***MODIFICATION REQUEST:  
Residential Development Stage 1 Phase 1  
Royal Rehabilitation Centre, Ryde  
MP10\_0189***

***Modifications to Residential Flat Building***

Director-General's  
Environmental Assessment Report  
Section 75W of the  
*Environmental Planning and Assessment Act 1979*

September 2012

Drawing Title			
APARTMENT - SECTIONS			
Drawing Number	Revision	Date	
A-PA-FP-AS	02	2012-03-30	
Issued for	Scale	Drawn	
PA	1:200@A1	RB	
0 1 2 3 4 5 10m			
Cox Architecture Pty Ltd ACN 002 535 891

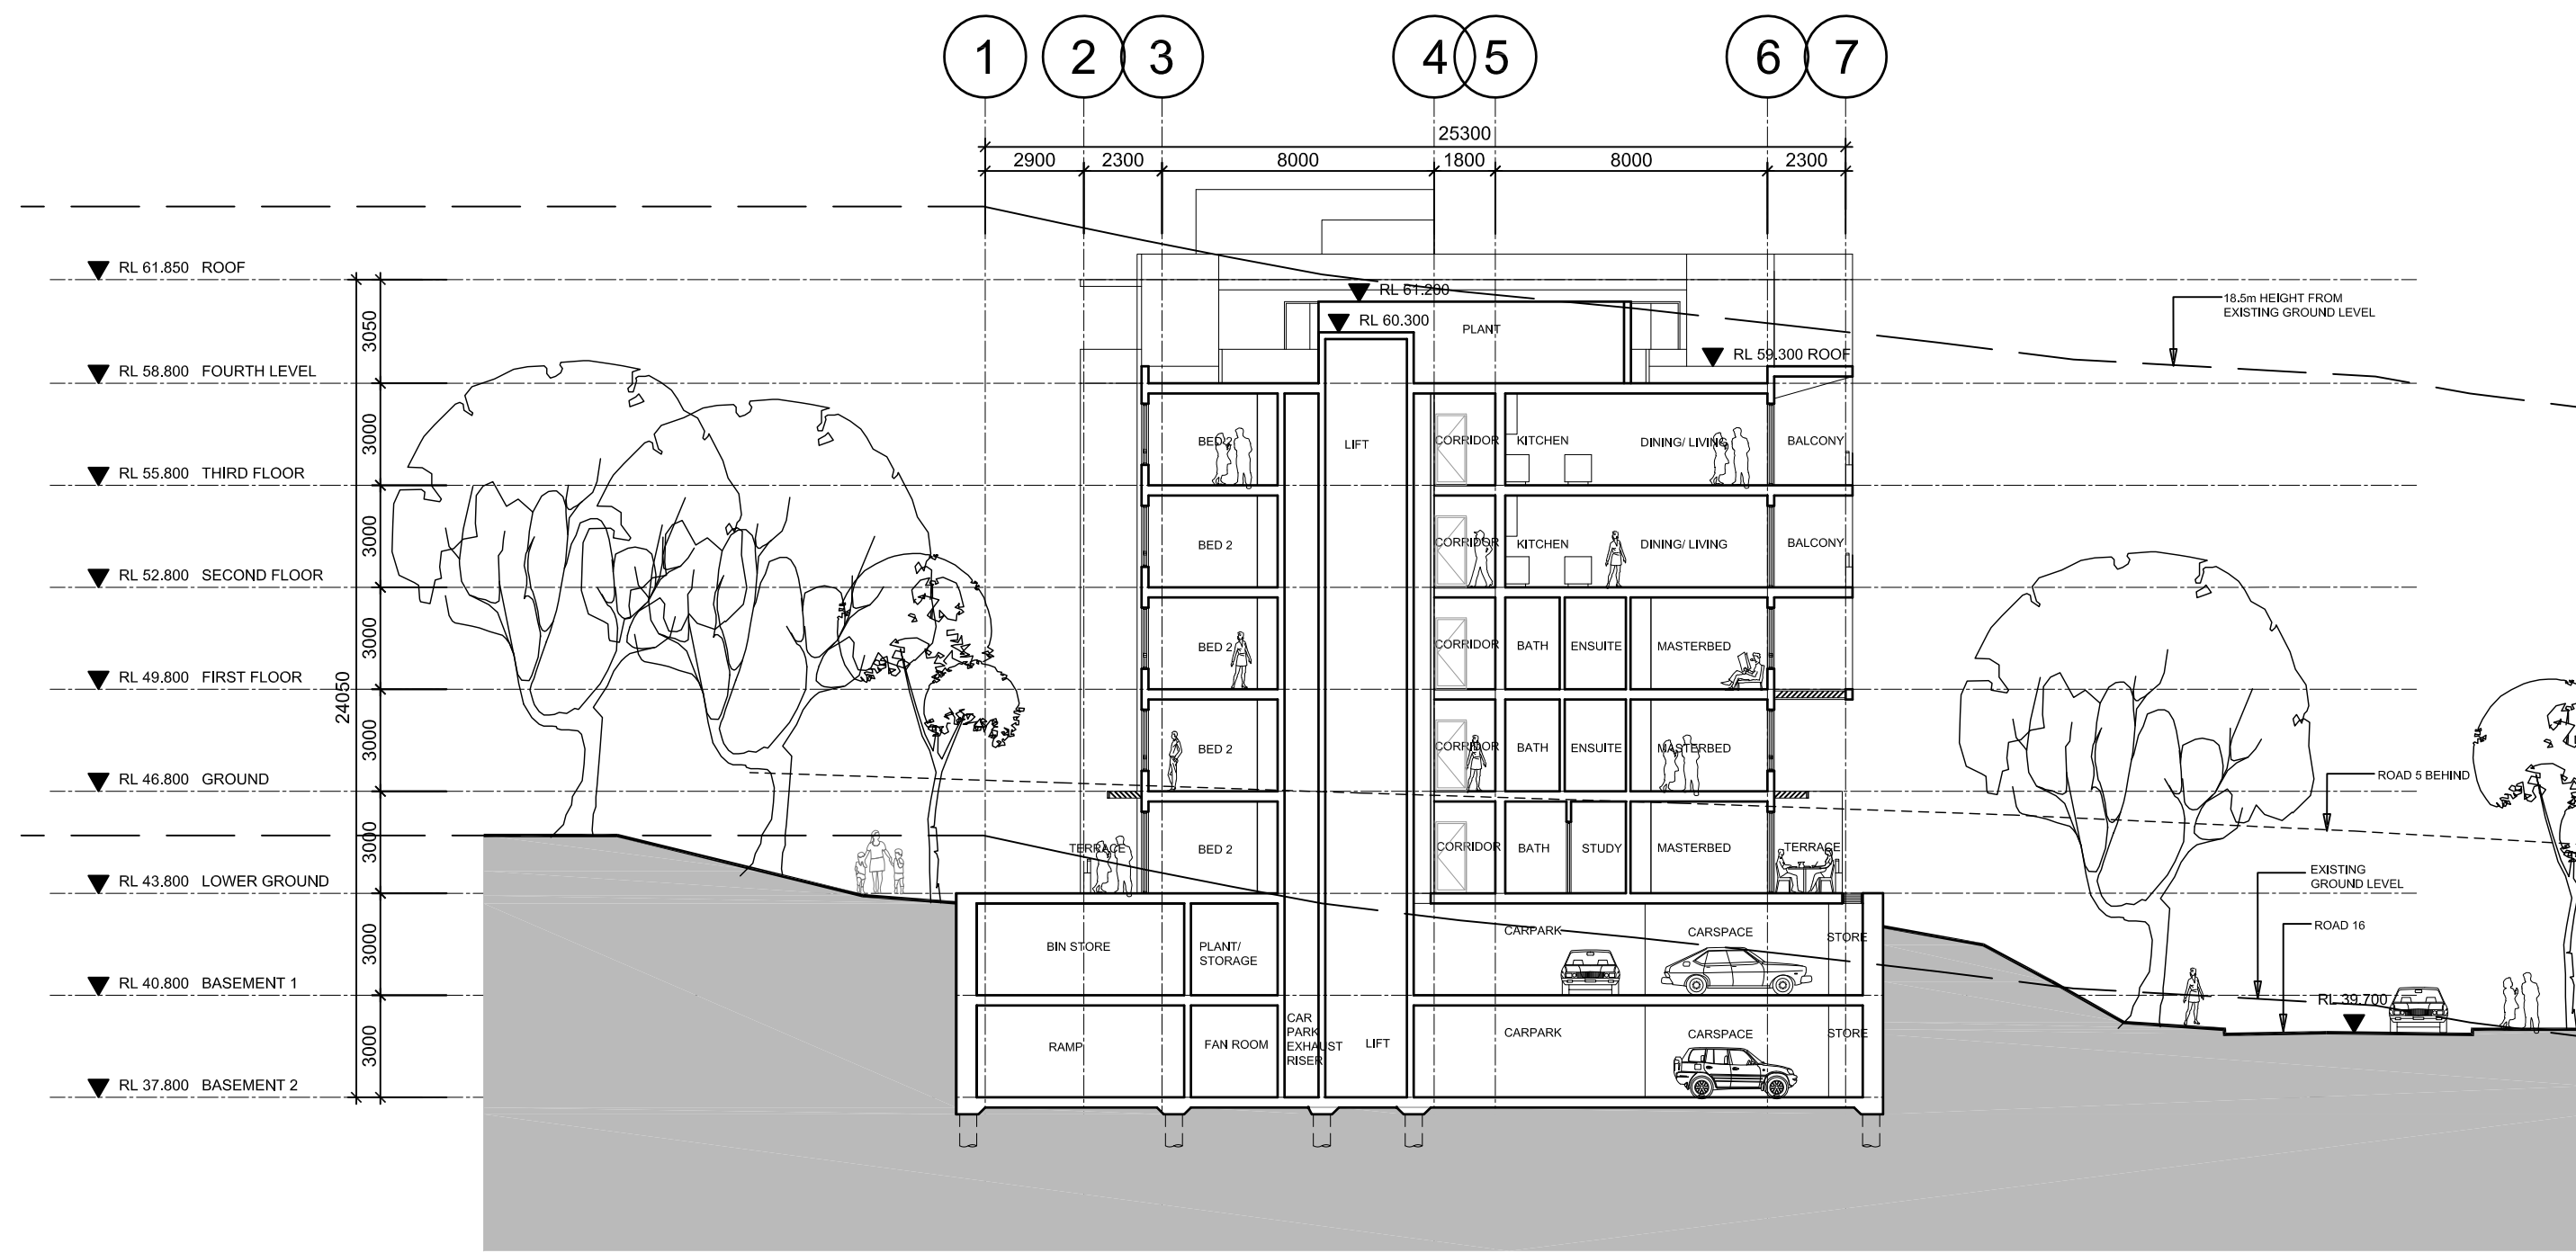
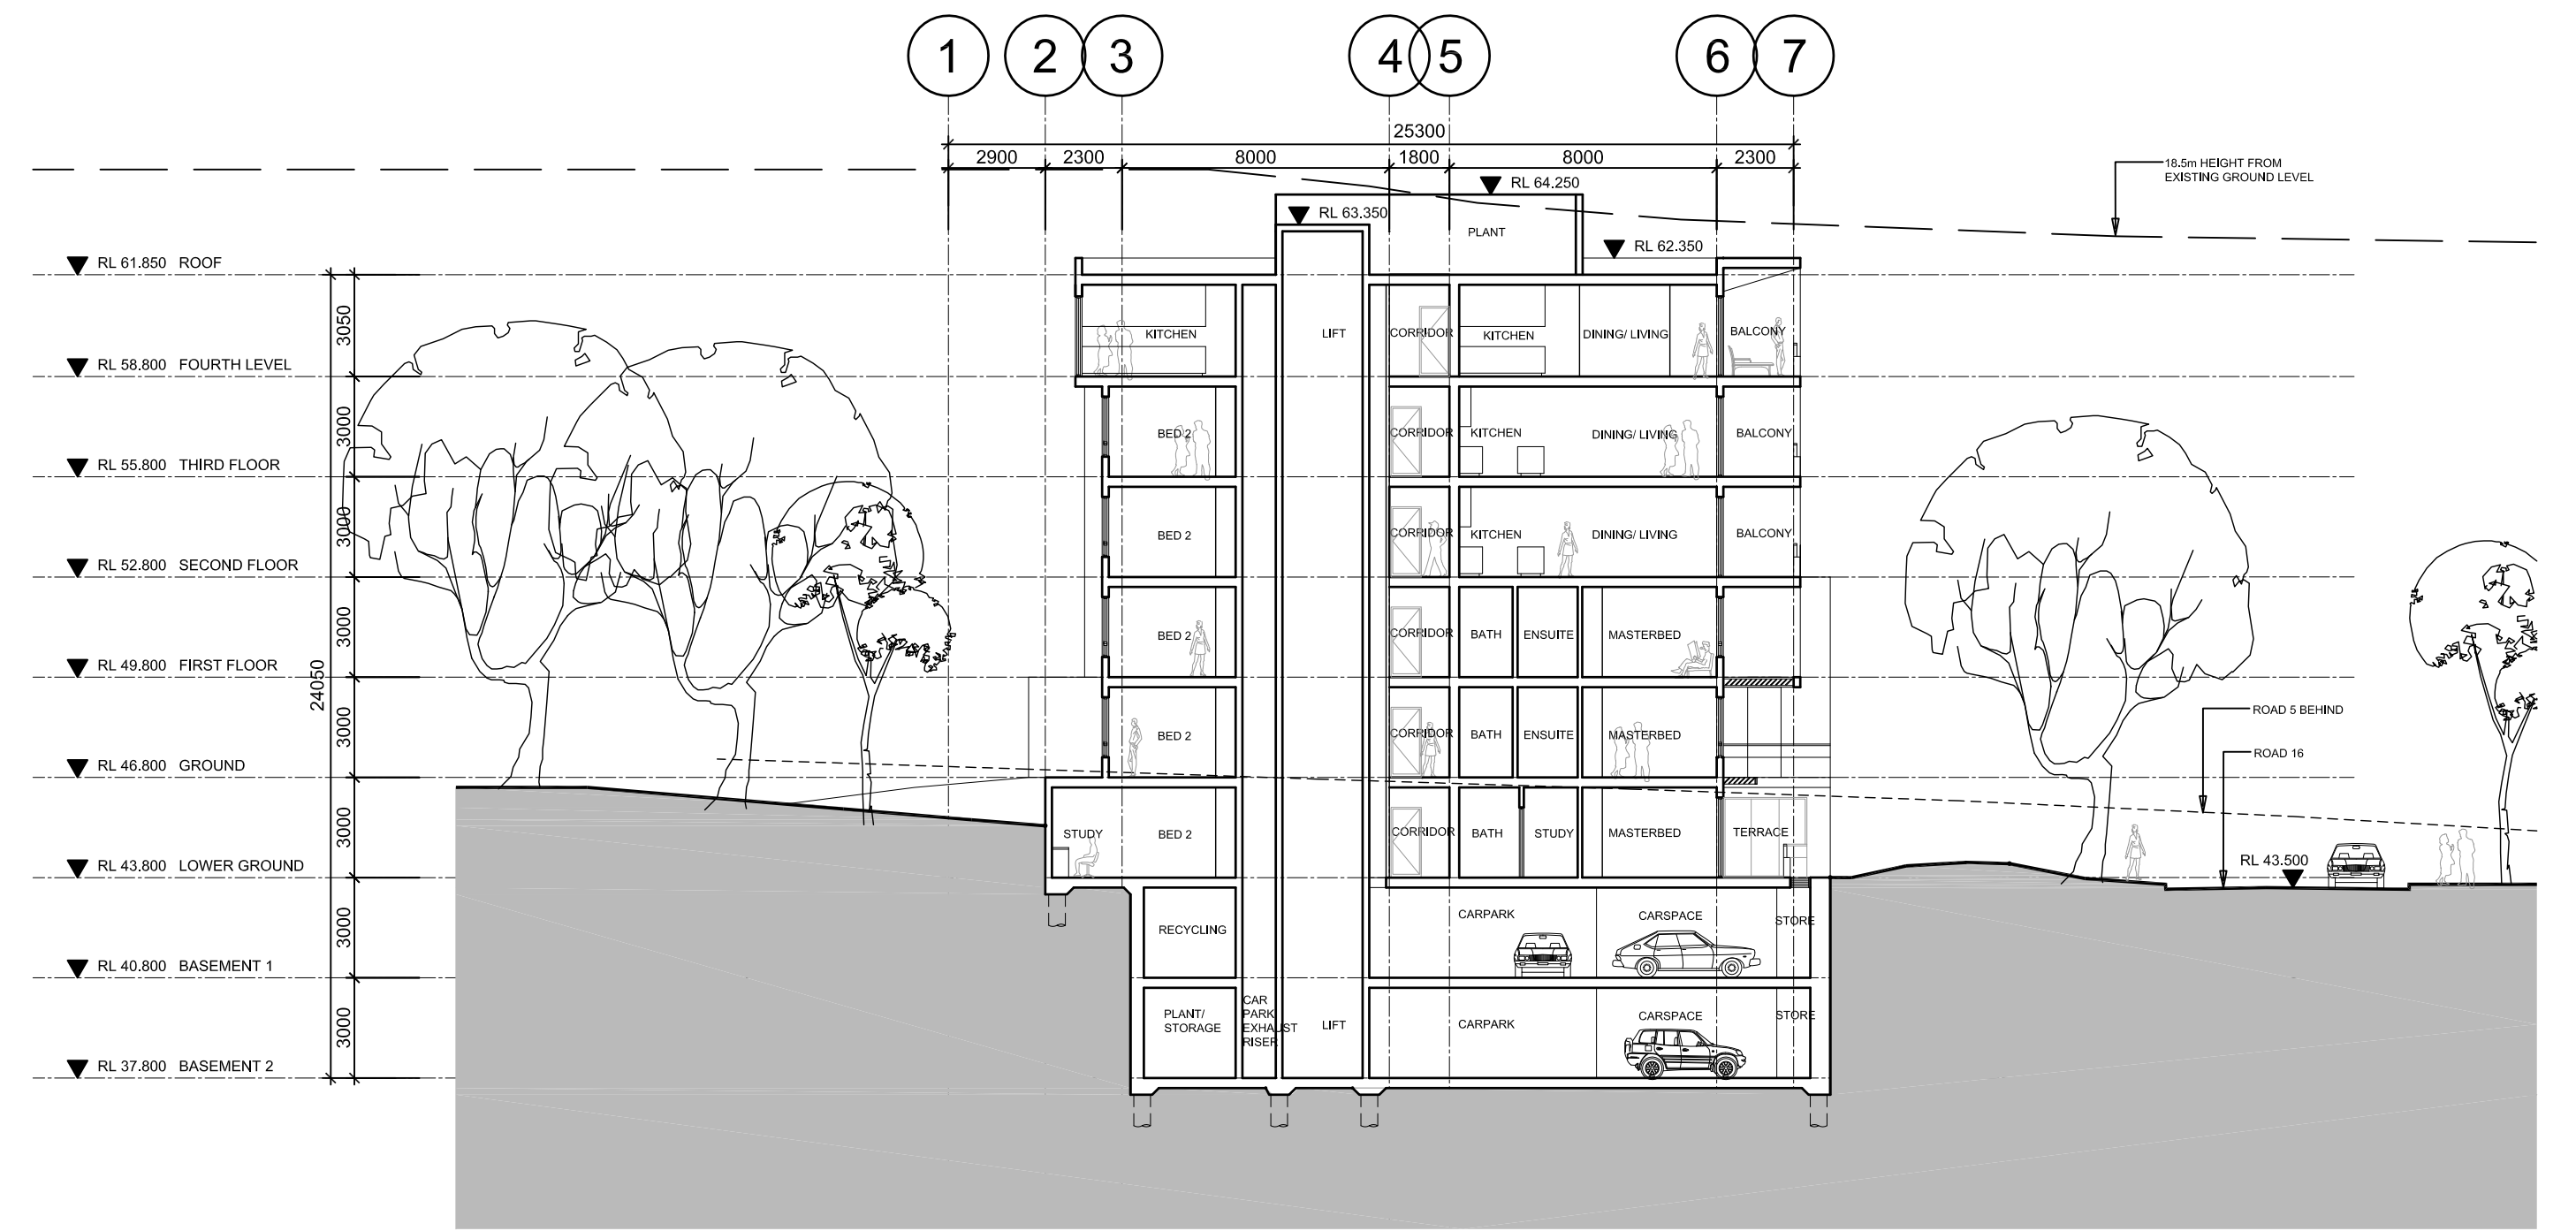
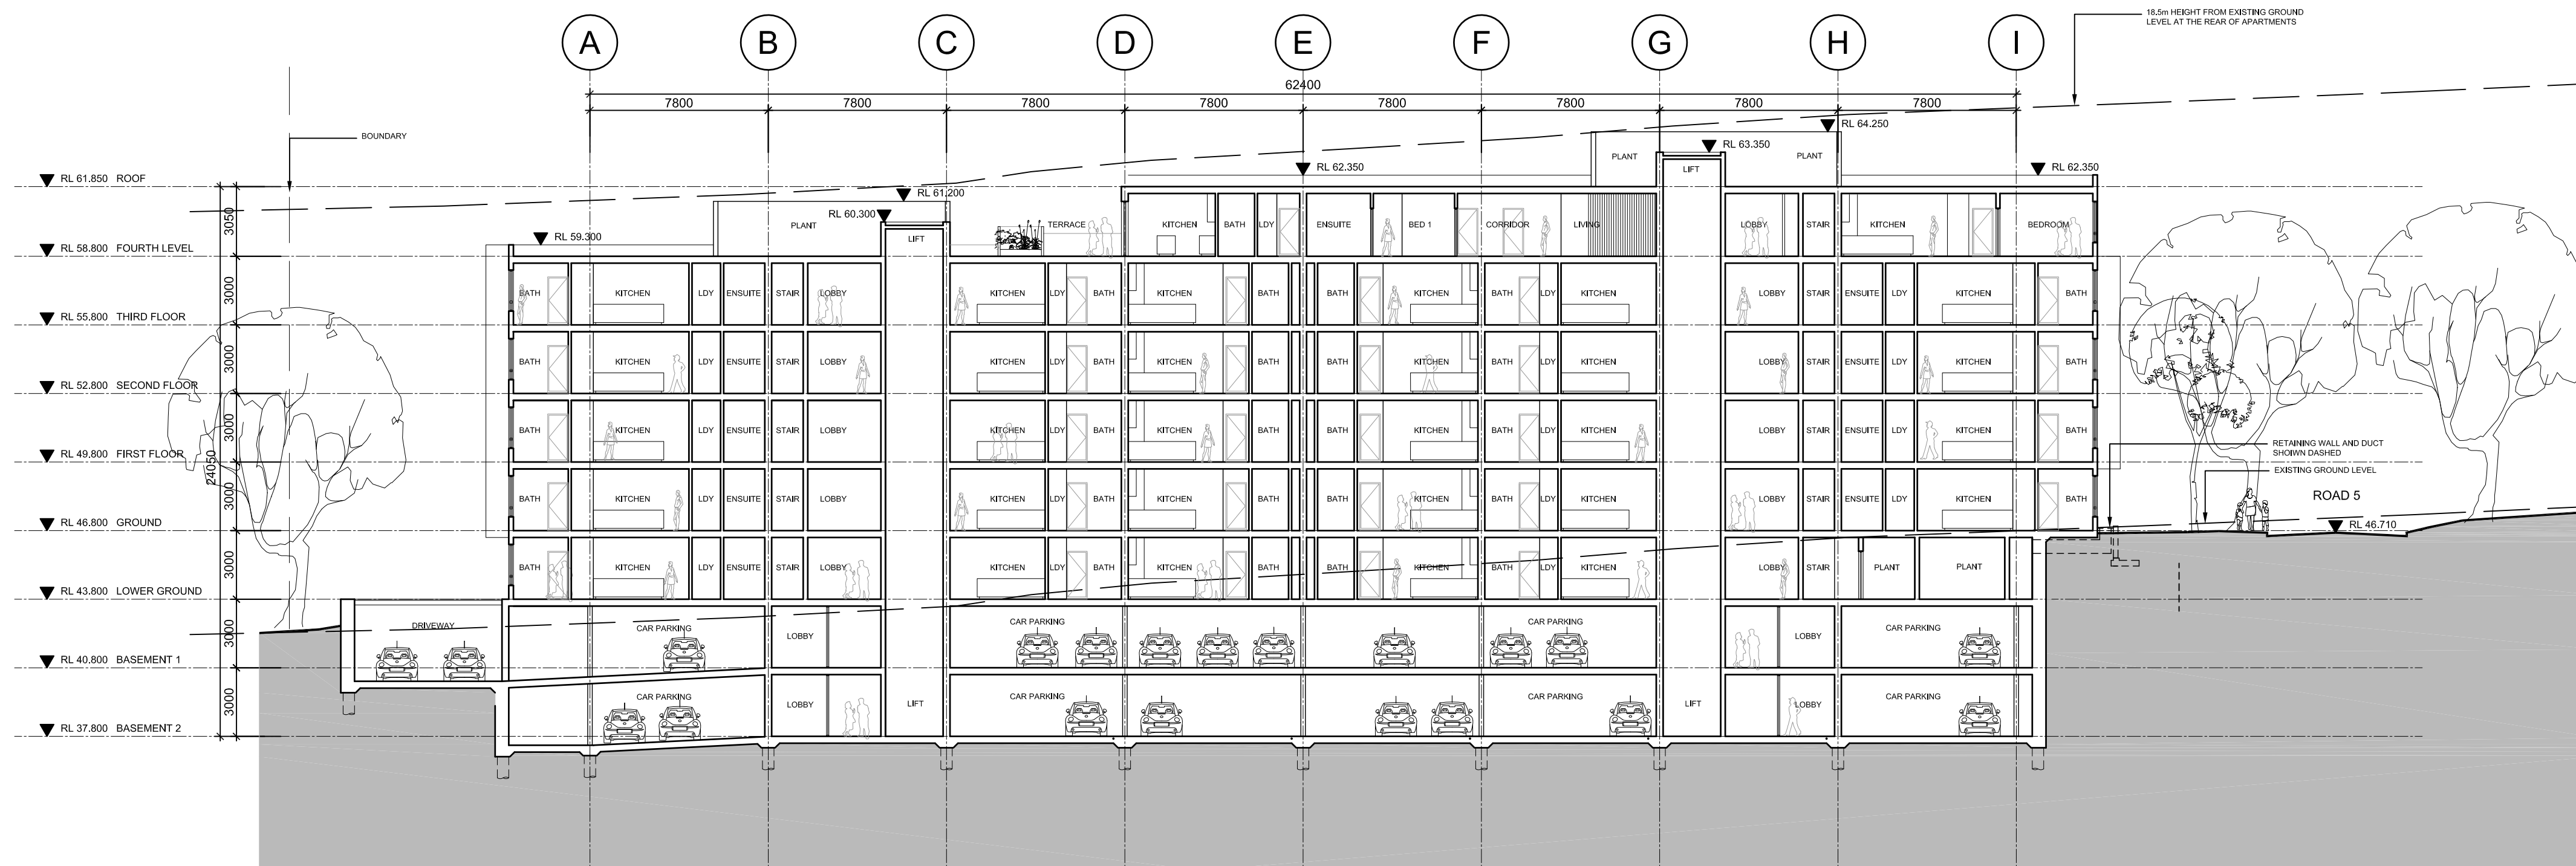
While the highest point of the modified building would only be only 0.25 metres higher than that approved, some parts of the building are increased in height by as much as 3 – 6 metres. As a result, the proposal, in particular the roof top plant, no longer fully complies with the 18.5 metre height control under the Ryde Local Environmental Plan (LEP).

Given that the proposed building will be visible from the adjoining Calvary Retirement Village, it is considered that the visual impacts of the building should be no greater than that permitted under the controls. A reduction in the height of the plant enclosures from 2.4 metres to 1.6 metres is required to ensure compliance with the LEP control. The proponent advises that it is possible to screen all plant with a 1.6 metre high enclosure and as such a condition is recommended requiring the plans to be amended so that all plant screening is within the 18.5 metre height limit.

As discussed in Section 5.1, a condition is recommended requiring a reduction in height to comply with the 18.5 metre control.
